From:
Sent: 09 March 2026 12:59
To: DC Admin
Subject: 2025/60/93572/E - objection - FAO E Thornhill

I am writing to raise further concerns regarding the above planning application, specifically in relation to the access details that have been submitted.

I am writing to raise further concerns regarding the above planning application, specifically in relation to the design and access statement and the Park Lane arrangements that has been submitted

Layout For Illustration Purpose Only.

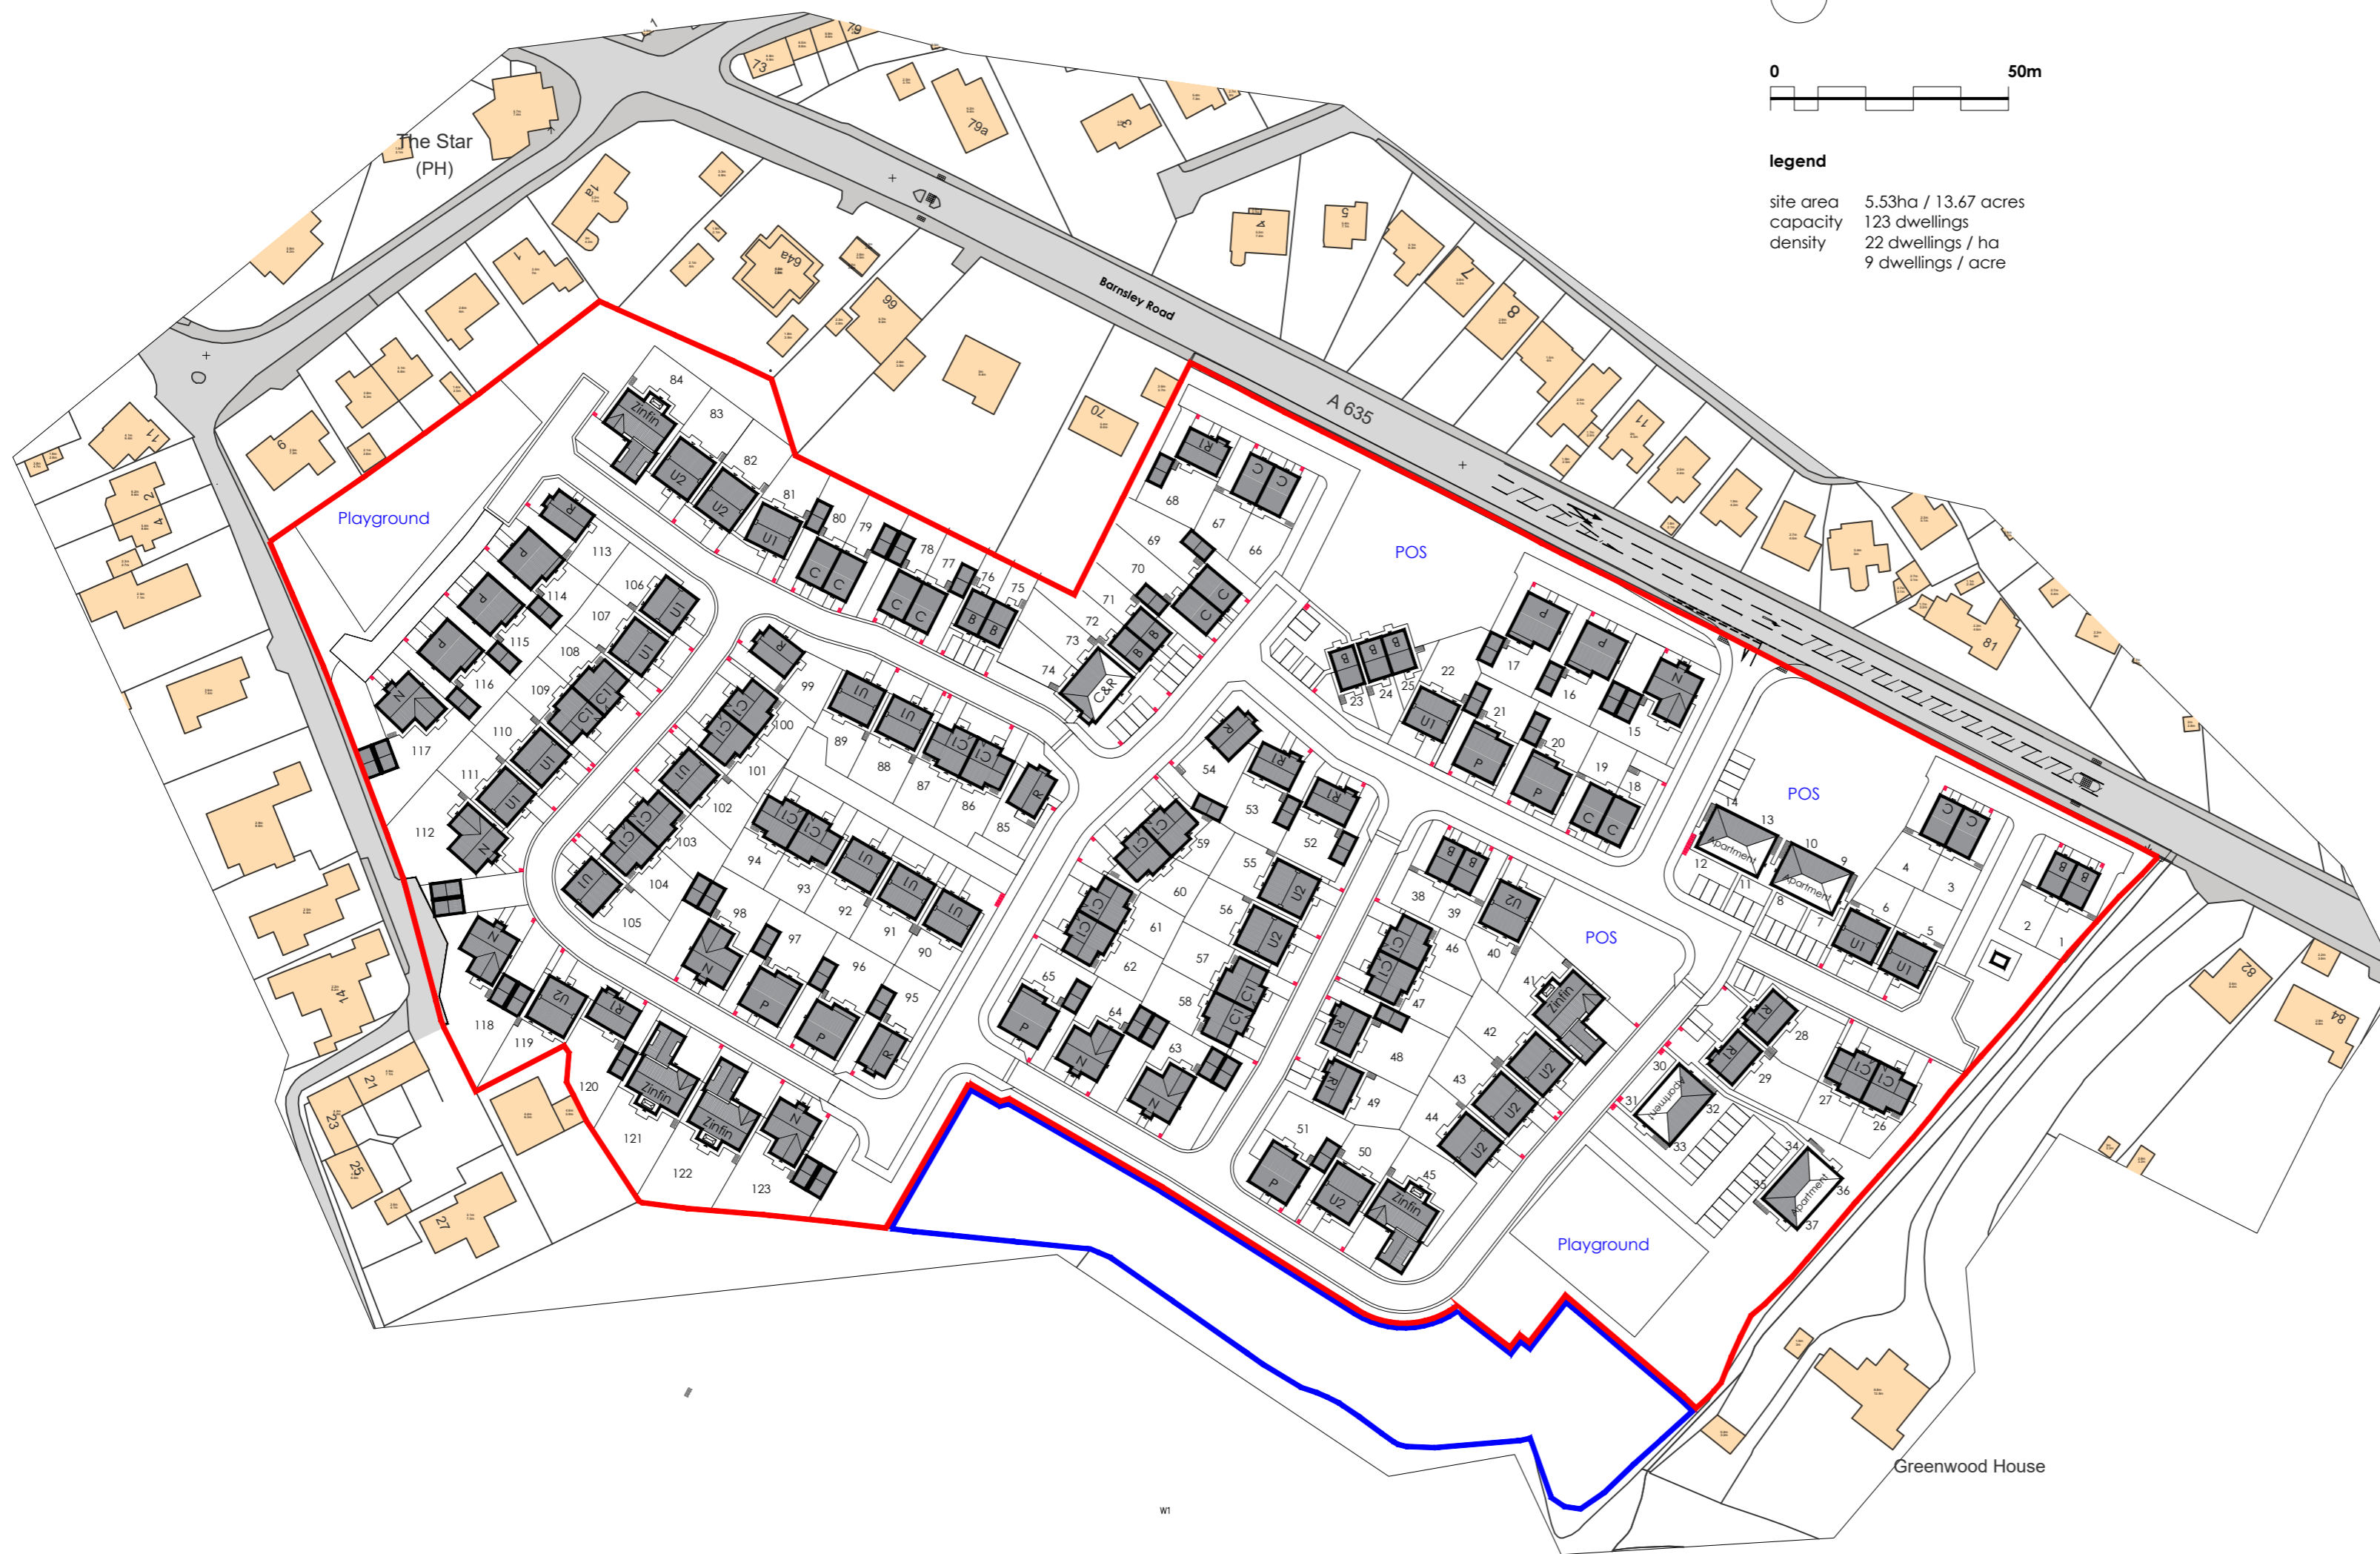
- The plans don't match the layout

- Parking is shown to be under providing
- Open space is under provision
- Red line is incorrect

- I have made design comments previously – the layout is not designed within the parameters required and cannot house 123 dwellings. This design must be landscape led not yield led.

KEY  
TACTILE PAVING

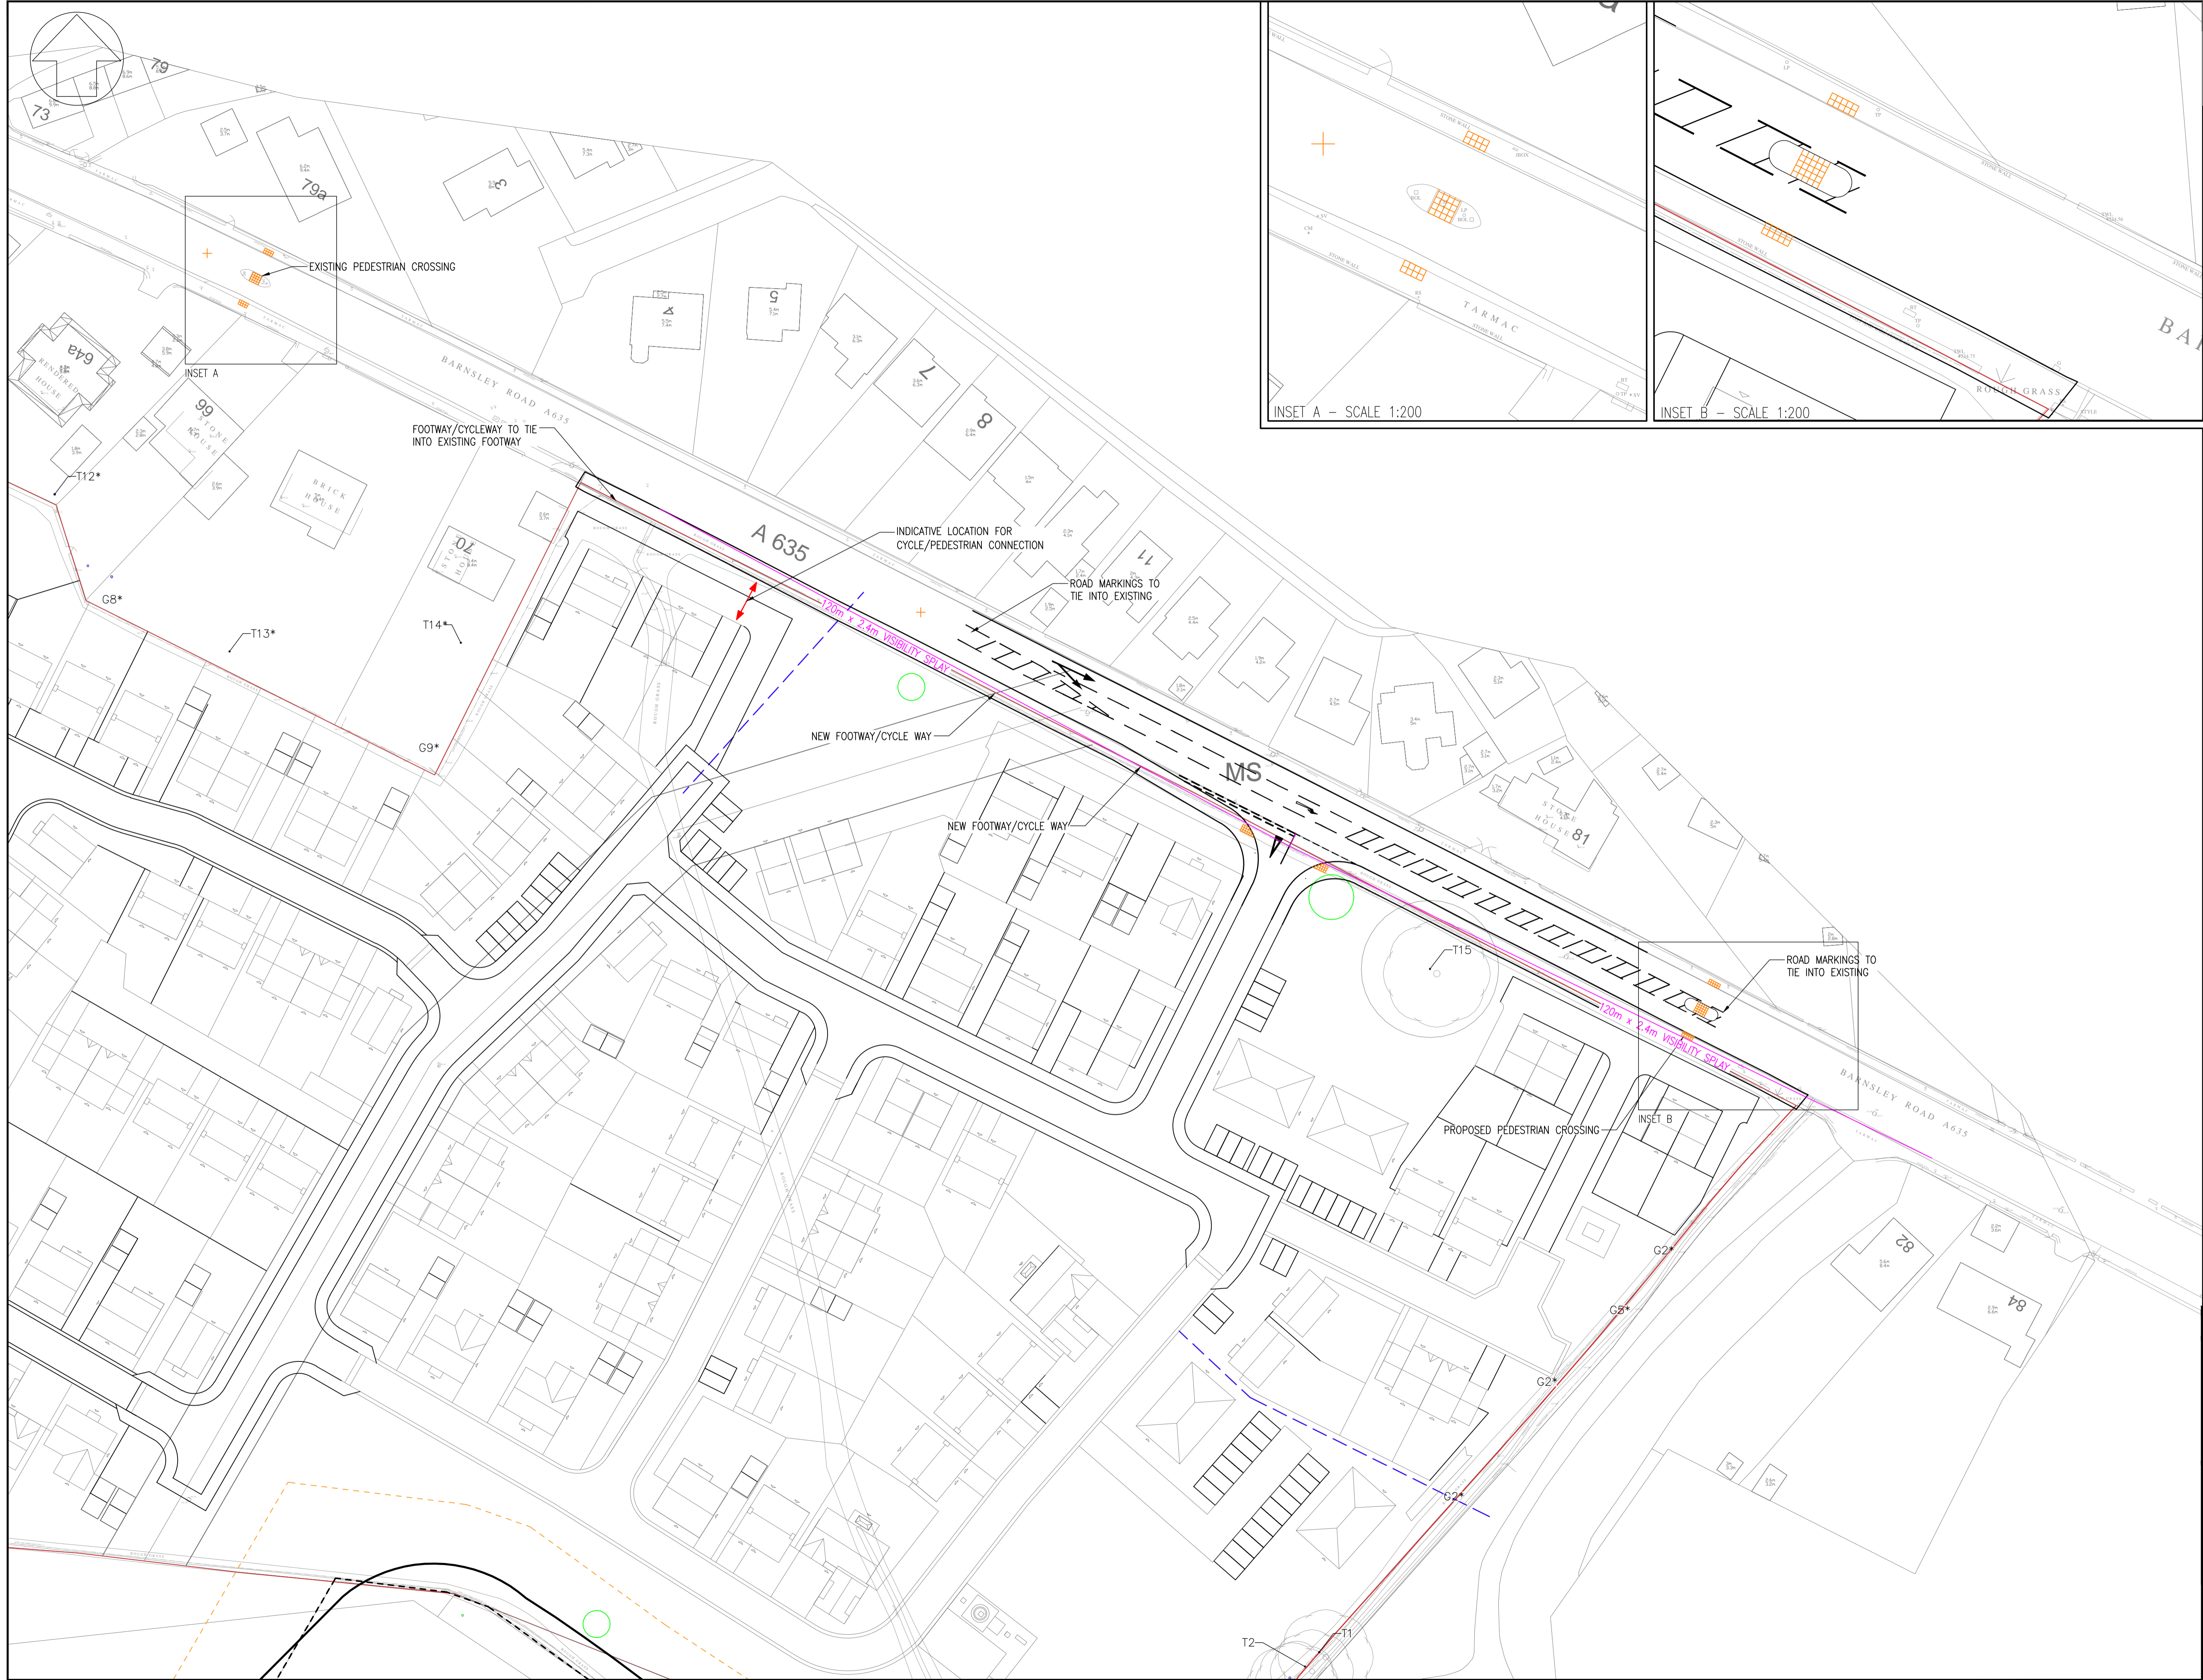
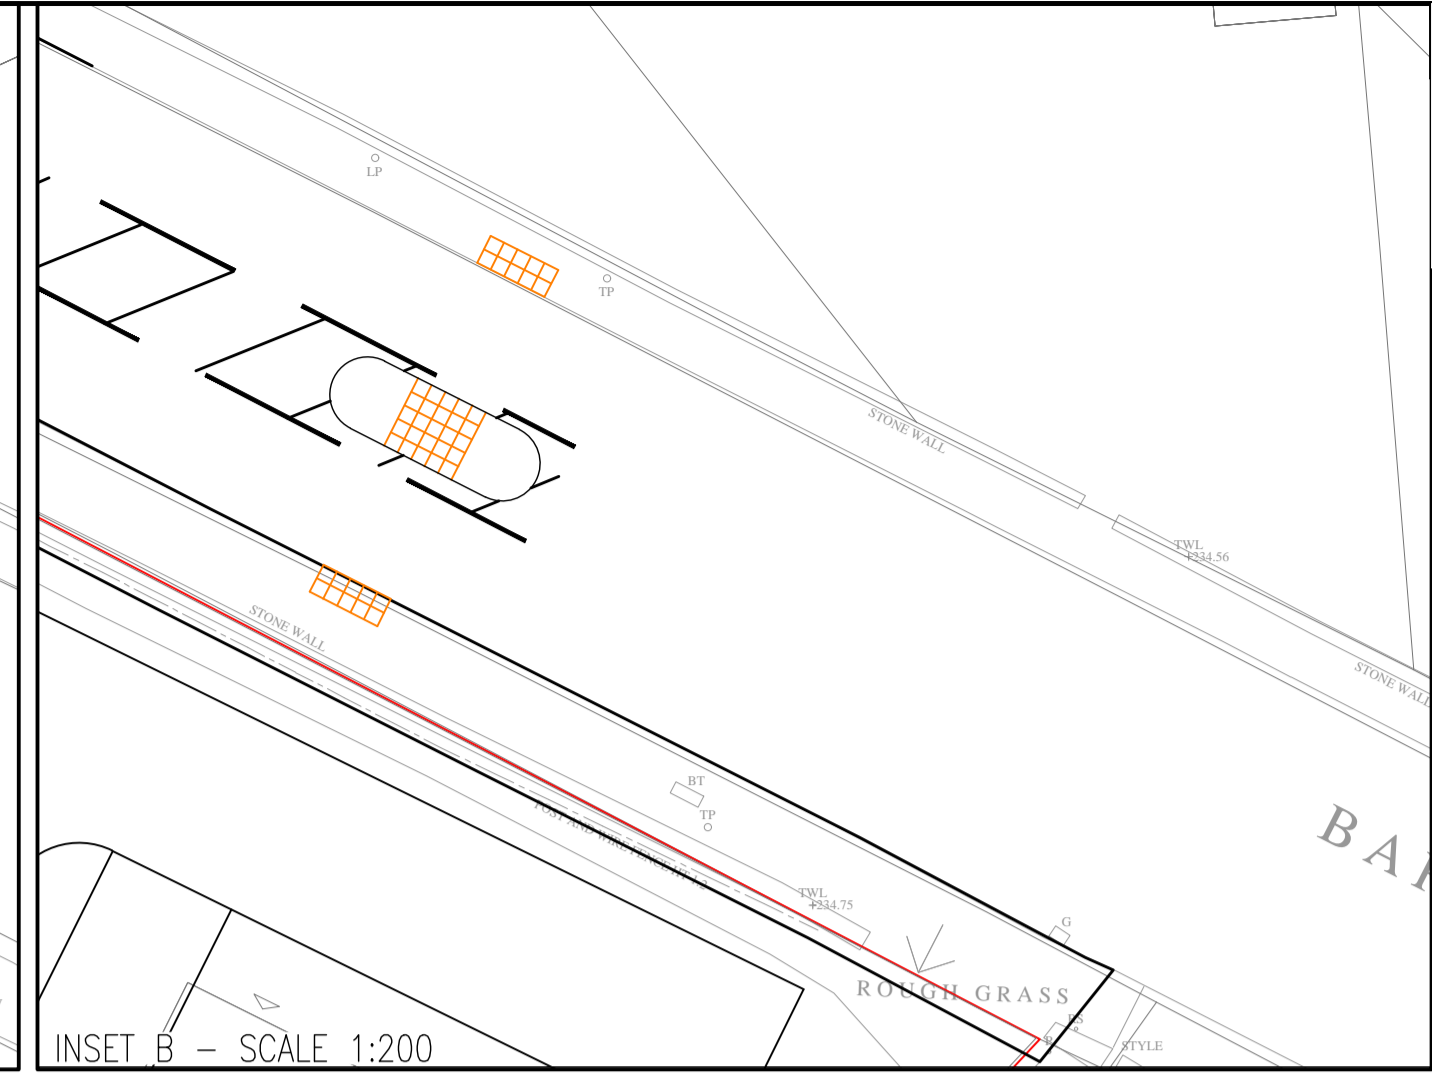
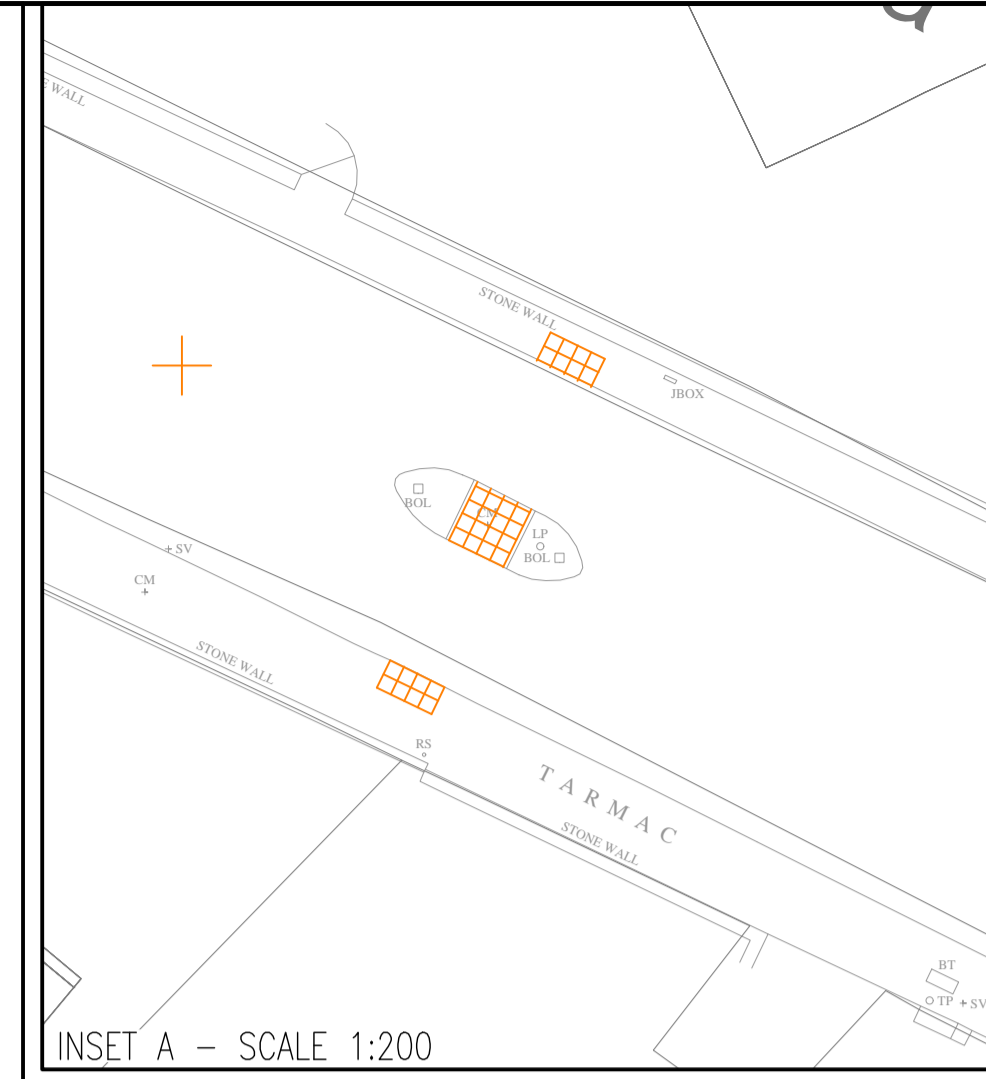
Although I have already lodged an objection to the application, a closer review of the submitted access drawings highlights several discrepancies between what is shown on the plans and the existing site conditions on the ground.

The field currently benefits from grass verges and traditional drystone walling along the boundary with Barnsley Road, both of which contribute significantly to the rural character of the area. In addition, there is an approximate level change of around 1 metre between Barnsley Road and the field itself. These existing features appear to have been disregarded within the submitted access plans.

The drawings appear to indicate that the drystone walling and grass verge would be removed or omitted entirely to facilitate the proposed access. Such an approach would be wholly inappropriate in this location. The retention of the drystone walls and grass verges is essential in order to preserve the established countryside character of the roadside frontage.

For clarity, the extract below demonstrates how the access arrangement should reflect the existing on-site conditions.
